## REFUSAL OF PLANNING PERMISSION

APPLICATION NO. 2017/1564

**Proposal** Erection of 1 no. block of two apartments.

**At** Three Horse Shoes Inn, 3 Barnsley Road, Brierley, Barnsley, S72 9JT

PROPOSED SITE PLAN

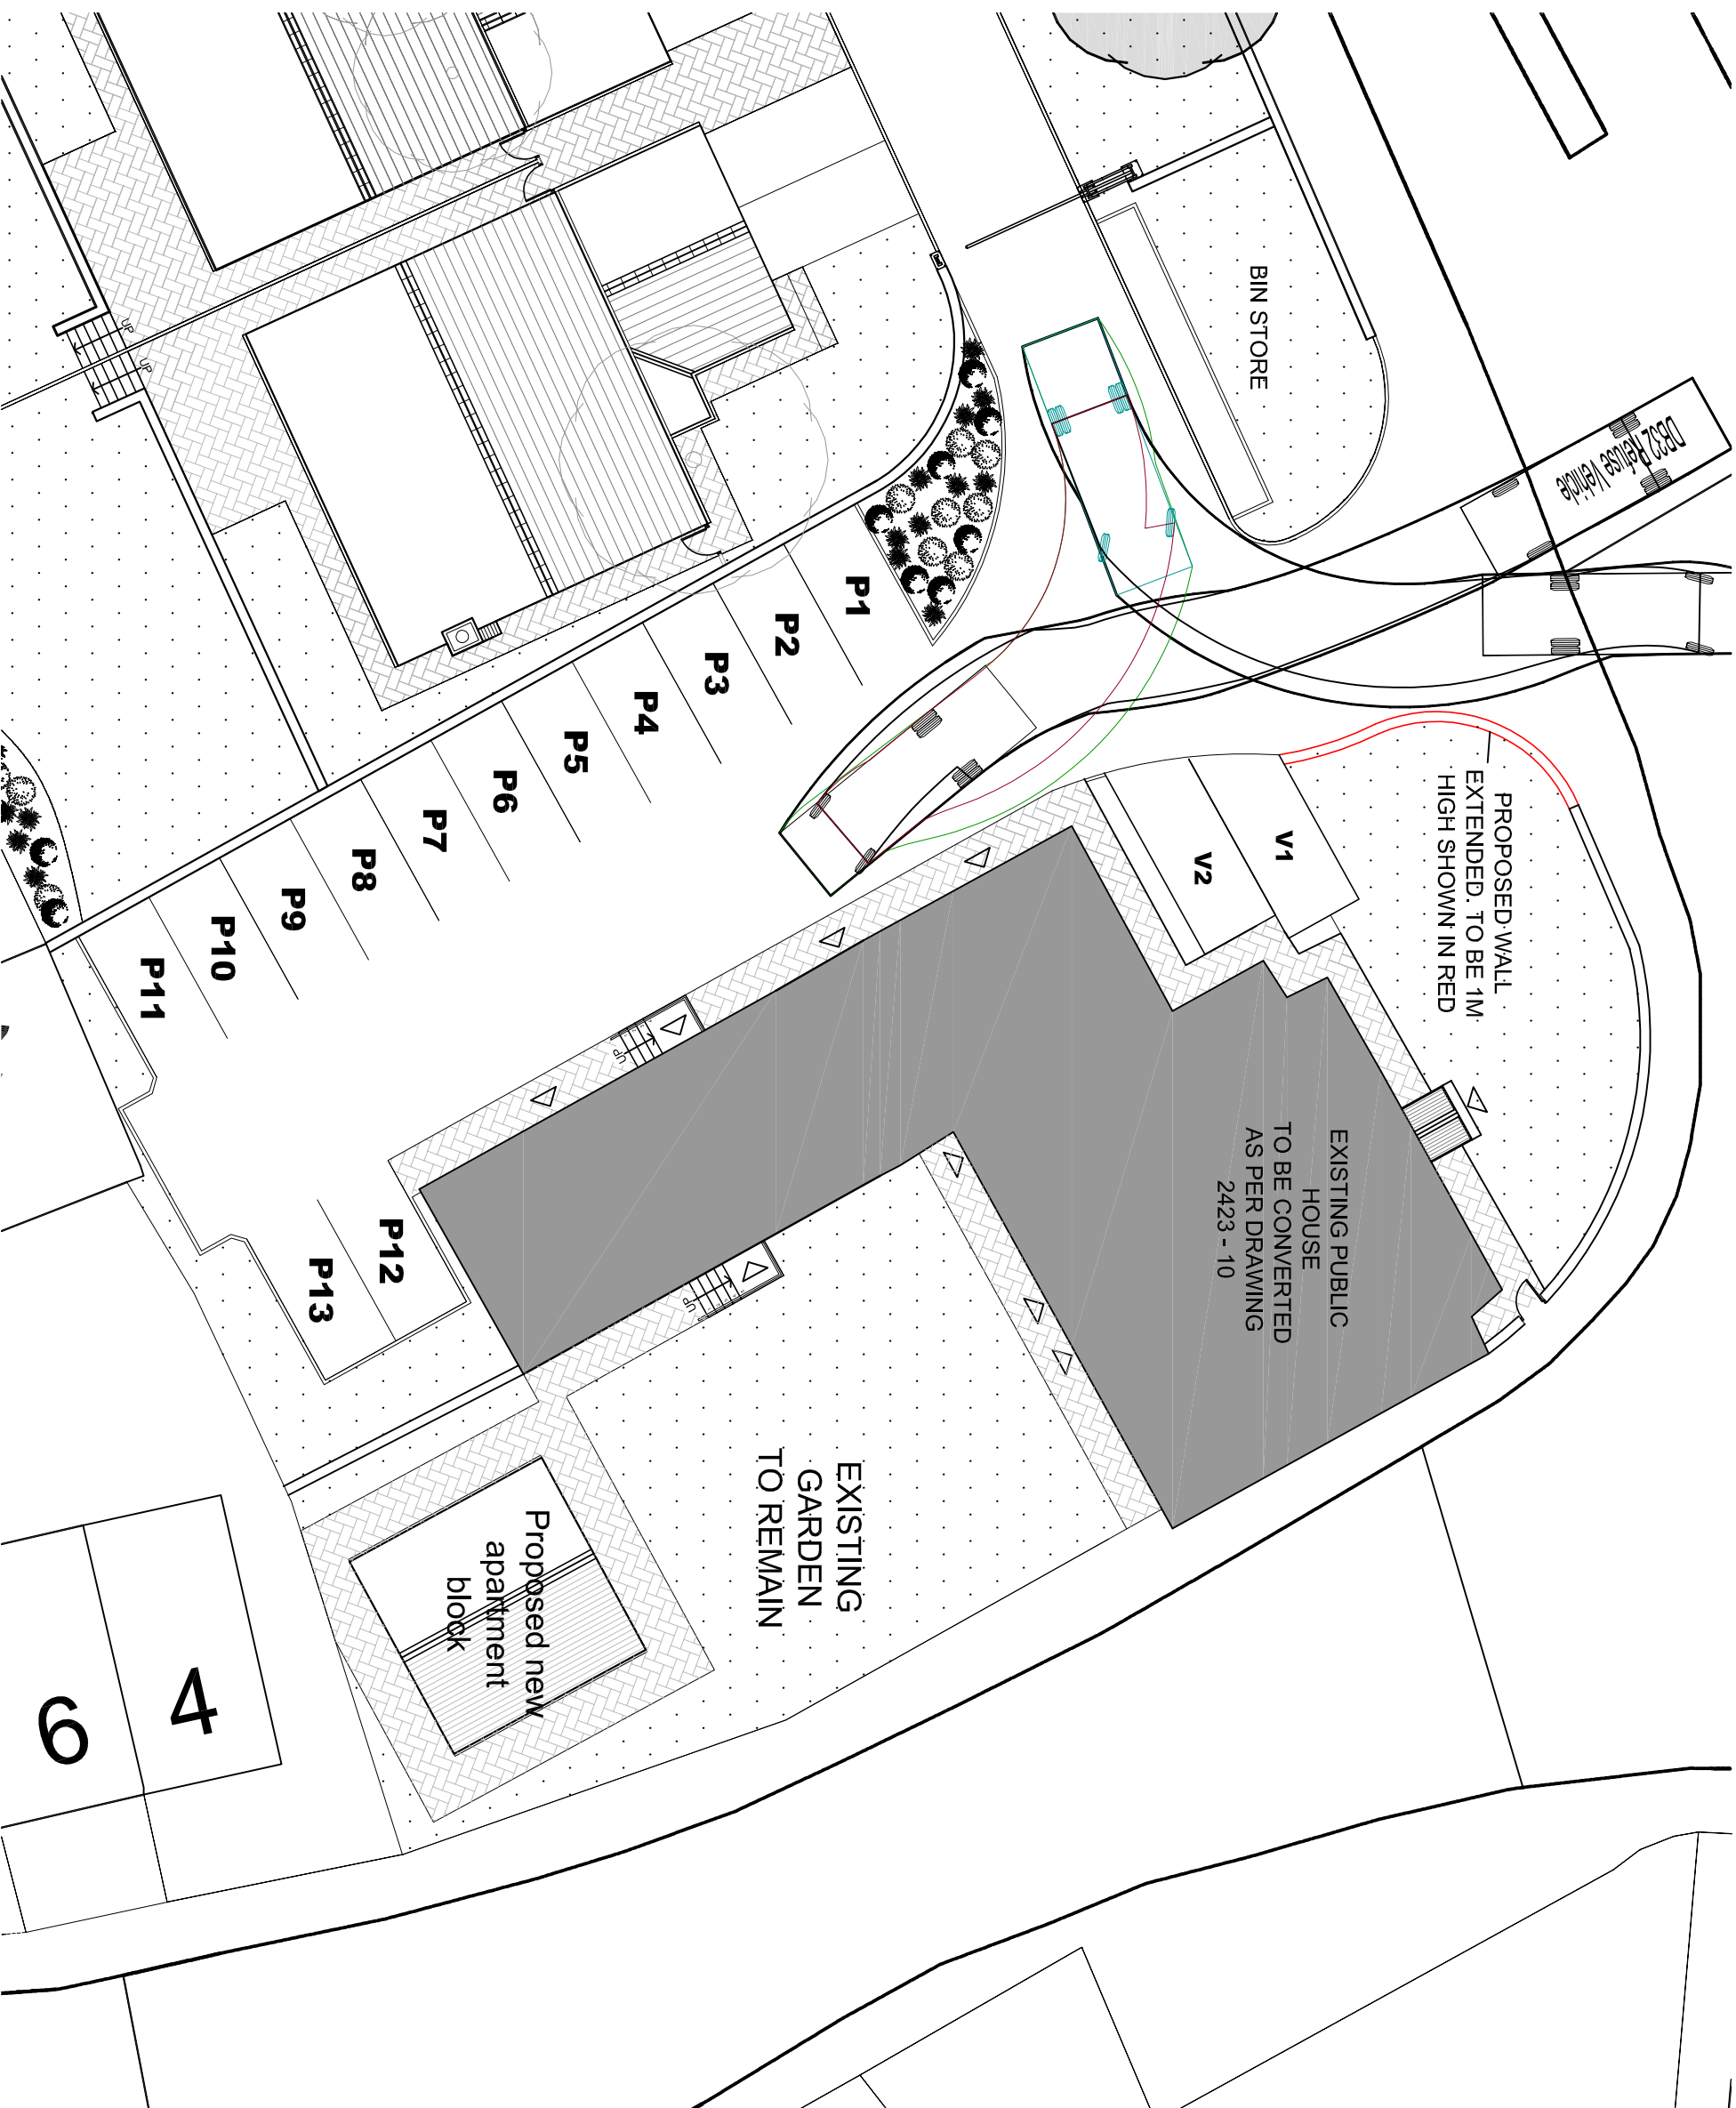
- 1 Due to the design, siting and scale, the proposed development would be materially harmful to the character and appearance of the Conservation Area. In addition, the proposed development would detract from the character and appearance of the former Three Horseshoes Public House, an attractive corner building at least 170 years old occupying a prominent position at a key gateway into Brierley Conservation Area. The proposal is therefore considered to be contrary to Core Strategy Policies CSP 29, Design and CSP 30, The Historic Environment and Section 12 of the NPPF.
